Engineers Comments Regarding Surface Water Drainage

Application Reference:	CM/16/26/HH	Reviewer Reference:	ADC/KW/PC
Planning Officer:	Rhiannon Lloyd	Date of Review:	17/08/2026
Site Name:	3 New Thatched Cottages, Climping Street		
Application Description:	Construction of detached garage/workshop with studio over.		
Assessment Number:	2 of 2

Drawing Name
Site Plan -
Proposed

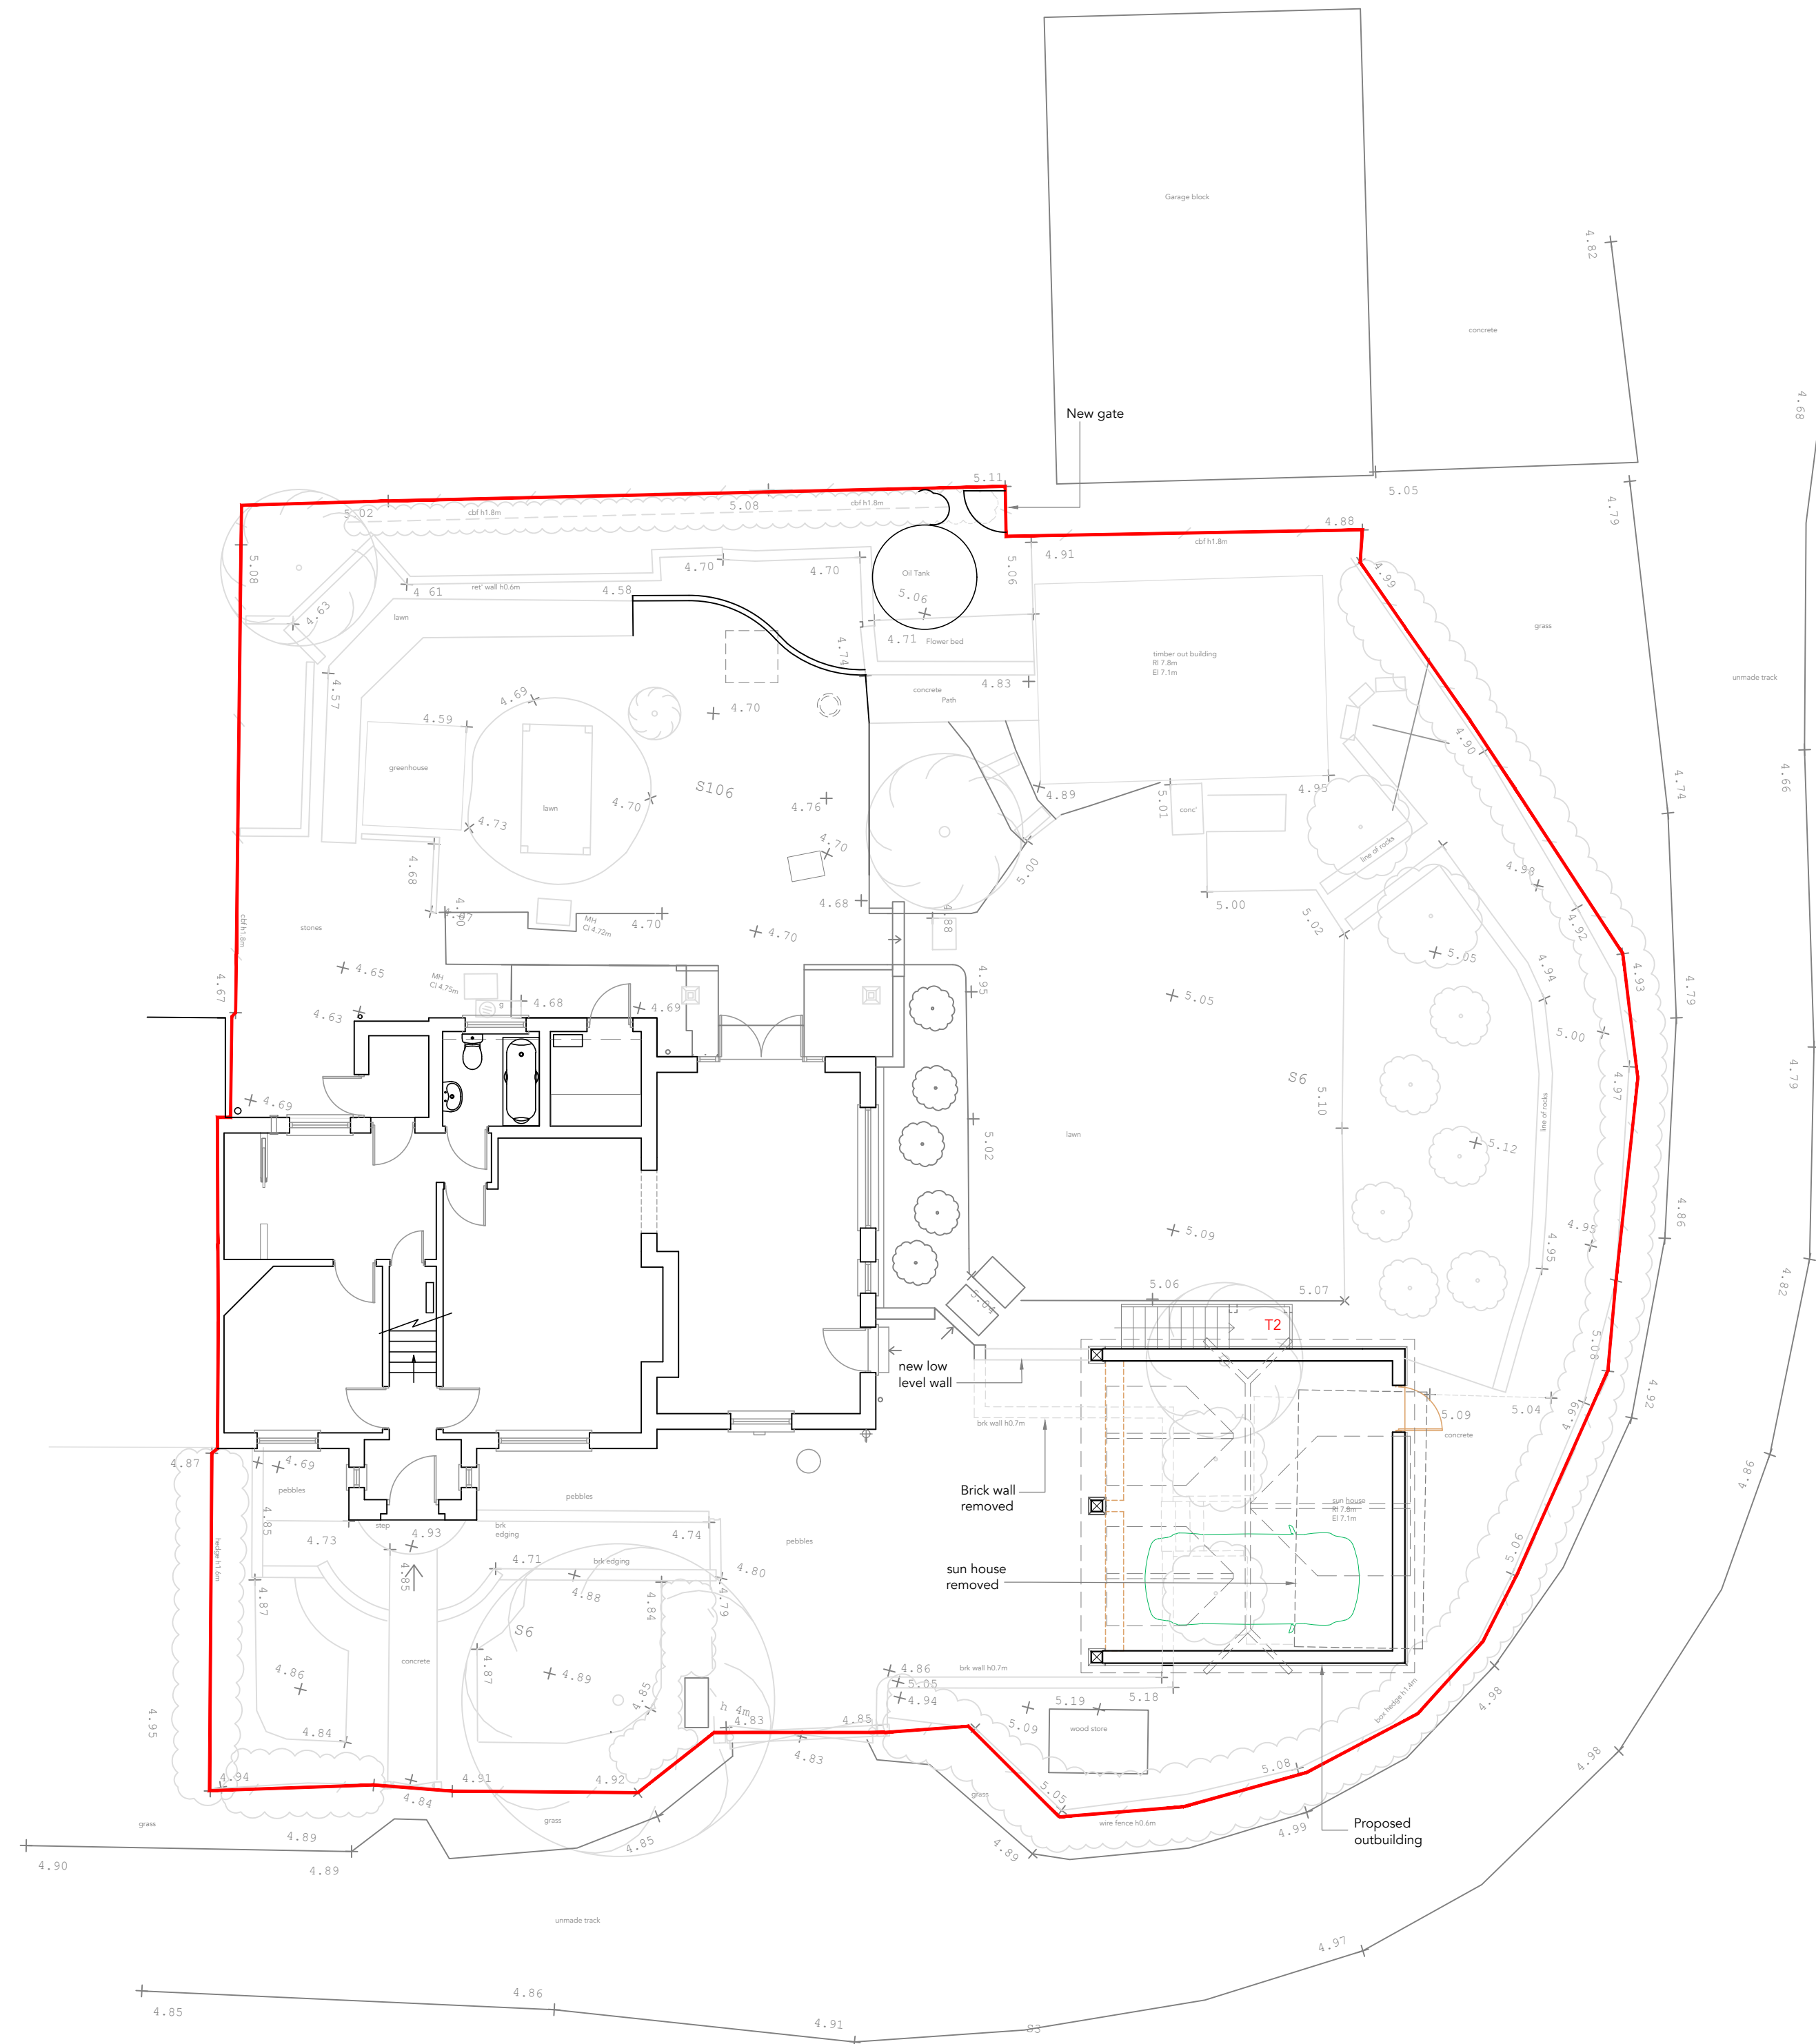
The proposed finished floor level shown on the plans is 5.15 mAOD. This is only slightly above the predicted flood level. **The Environment Agency should be consulted in this respect.**

© This drawing is the copyright of Robert Clark BSc CEng MICE It may not be copied or reproduced without his written authority	Scale As shown	At original A3
Drawing Number 2139/D3	Revision -

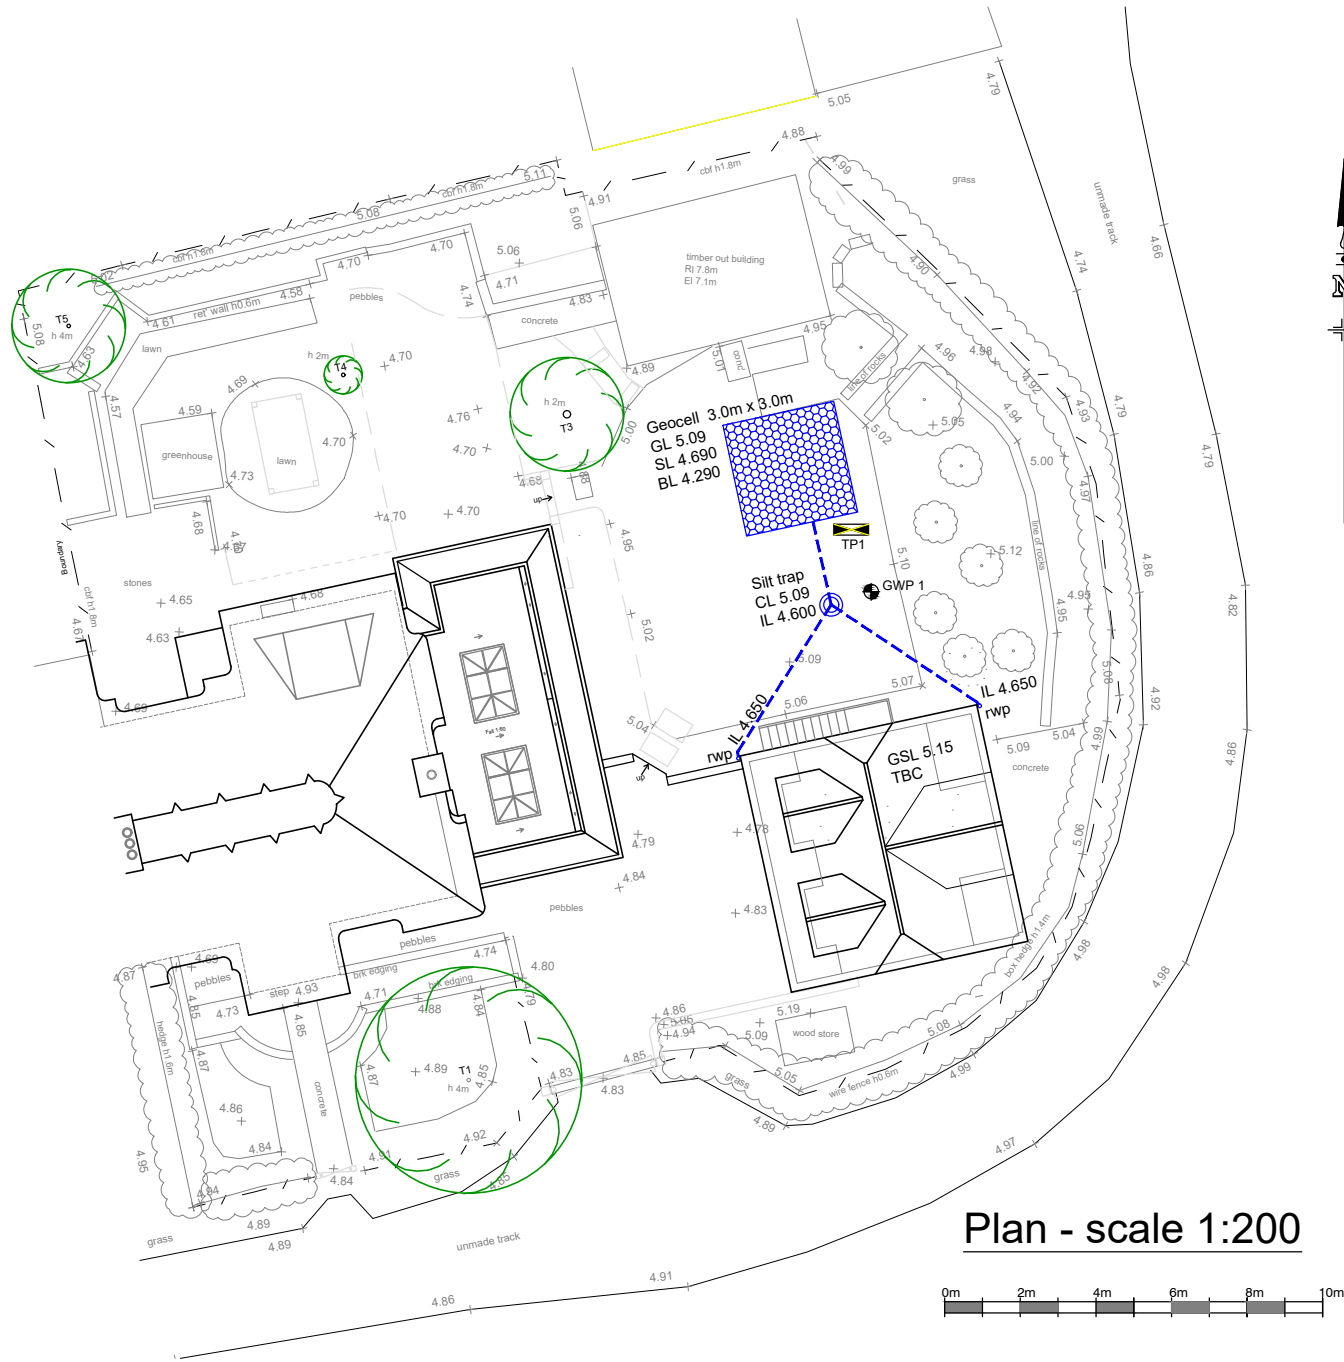
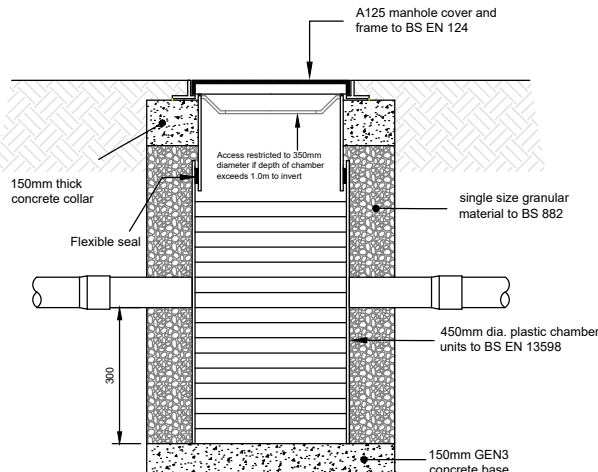
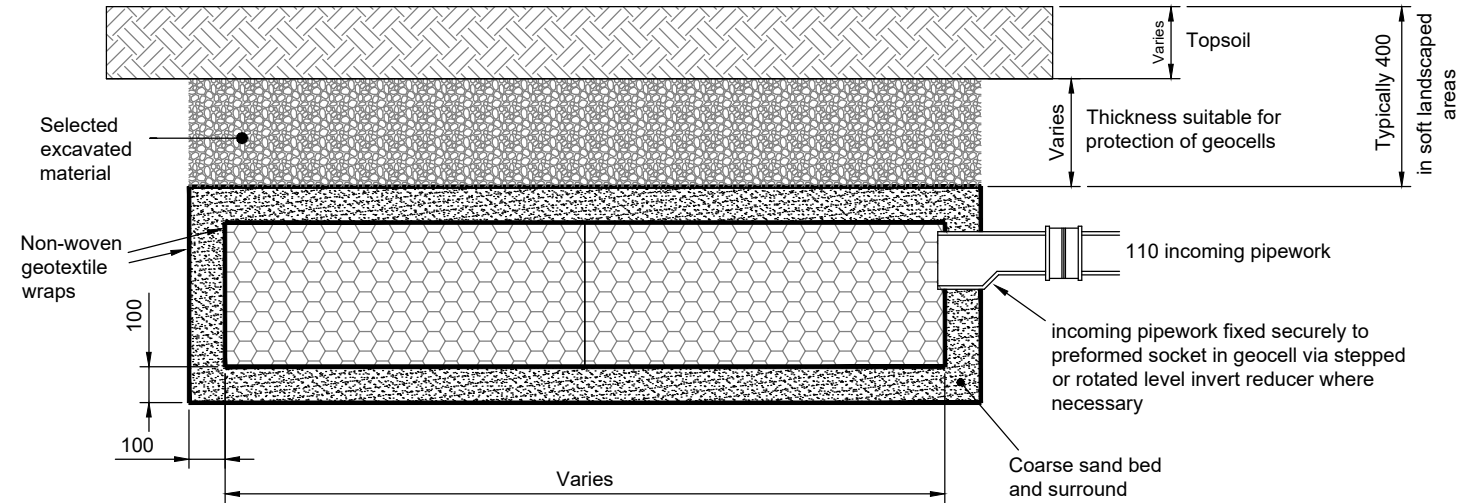
It is proposed to manage surface water on site via a new soakaway. We support this approach in principle, as infiltration is the highest priority discharge location (after water re-use) in the drainage hierarchy and aligns with Standard 1 of the Non-Statutory Technical Standards for SuDS (NSfS).

Infiltration has been proven viable and the proposed system, to drain and infiltrate to is acceptable.

Storm calculations provided have not modelled the 1 in 2-year (50% AEP) event.

A contributing area plan should be provided showing all positively drained areas including open surface water storage plan areas. Urban creep at a rate of 10% is required to be applied to residential roof areas is required.

#3 New Thatched Cottages
Borehole #1 (South)

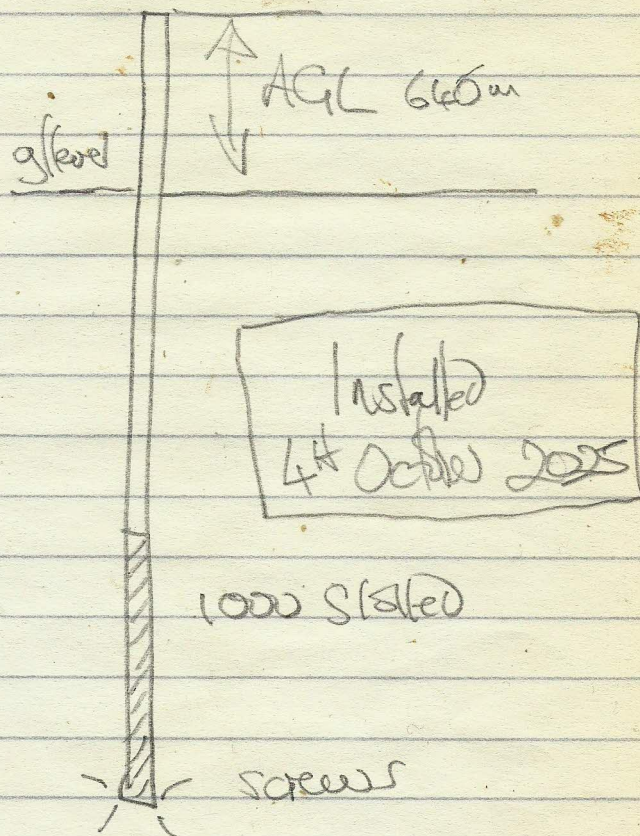
Groundwater monitoring undertaken during October 2025 – January 2026 at roughly weekly intervals which is acceptable. It demonstrates that groundwater peaks at 1.86m (bgl) below ground level.

Product 4 Flood Risk Data Requested by: Lauren Willard
Site: 500250,101362 (easting and northing coordinates)

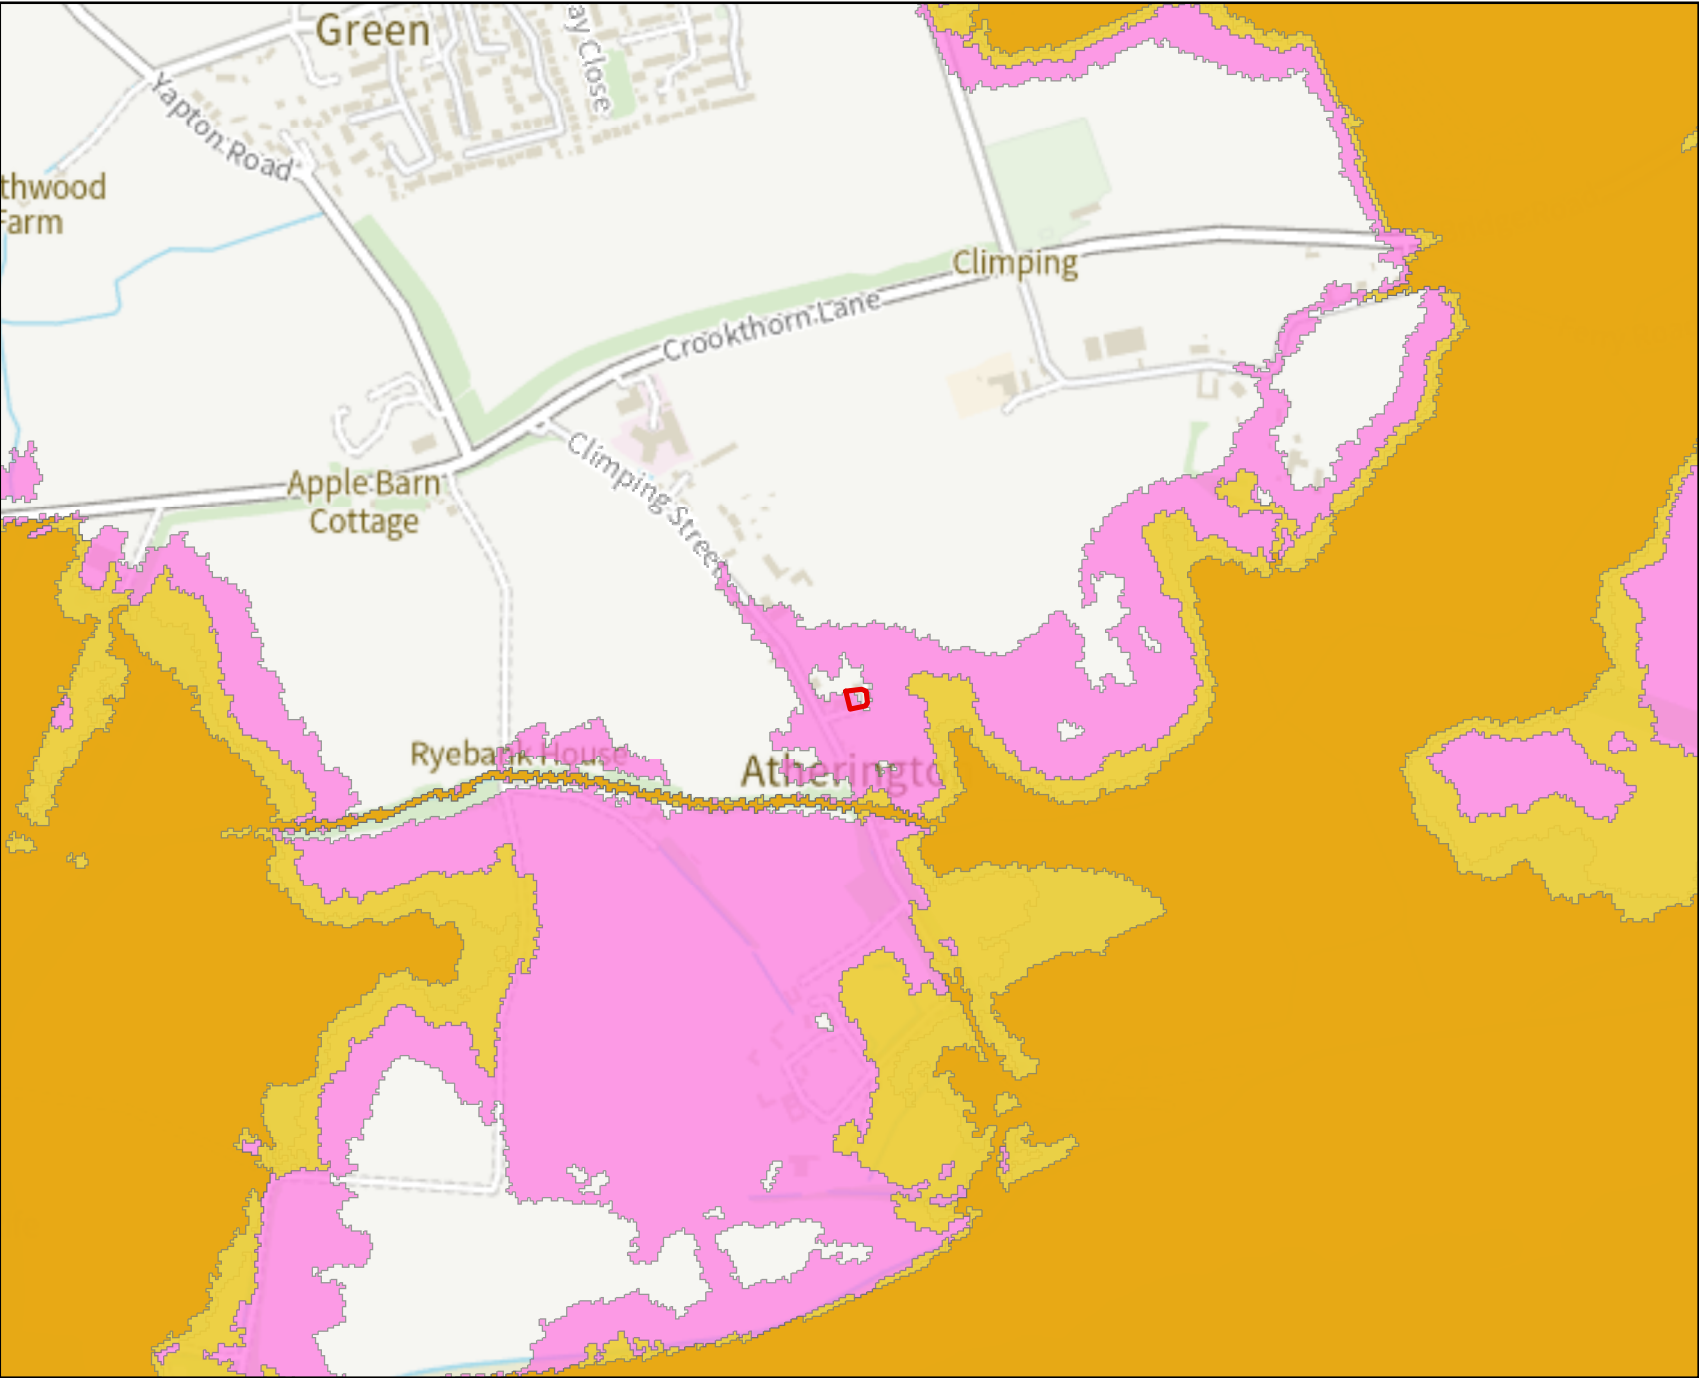
Sustainable Drainage Systems (SuDS) should ideally be located entirely within areas of Flood Zone 1 (FZ1) to avoid any interaction with areas identified as being at future risk of flooding. Product 4 data has been provided, indicating that approximately half of the site (to the west) will be at future risk of flooding from tidal sources during the 0.5% AEP event. The peak flood level is predicted to be 4.94 mAOD, which would result in flood depths across the site of between 2 cm and 9 cm. As the source and level of flooding has been evidenced, the proposed SuDS design is considered acceptable in this instance.
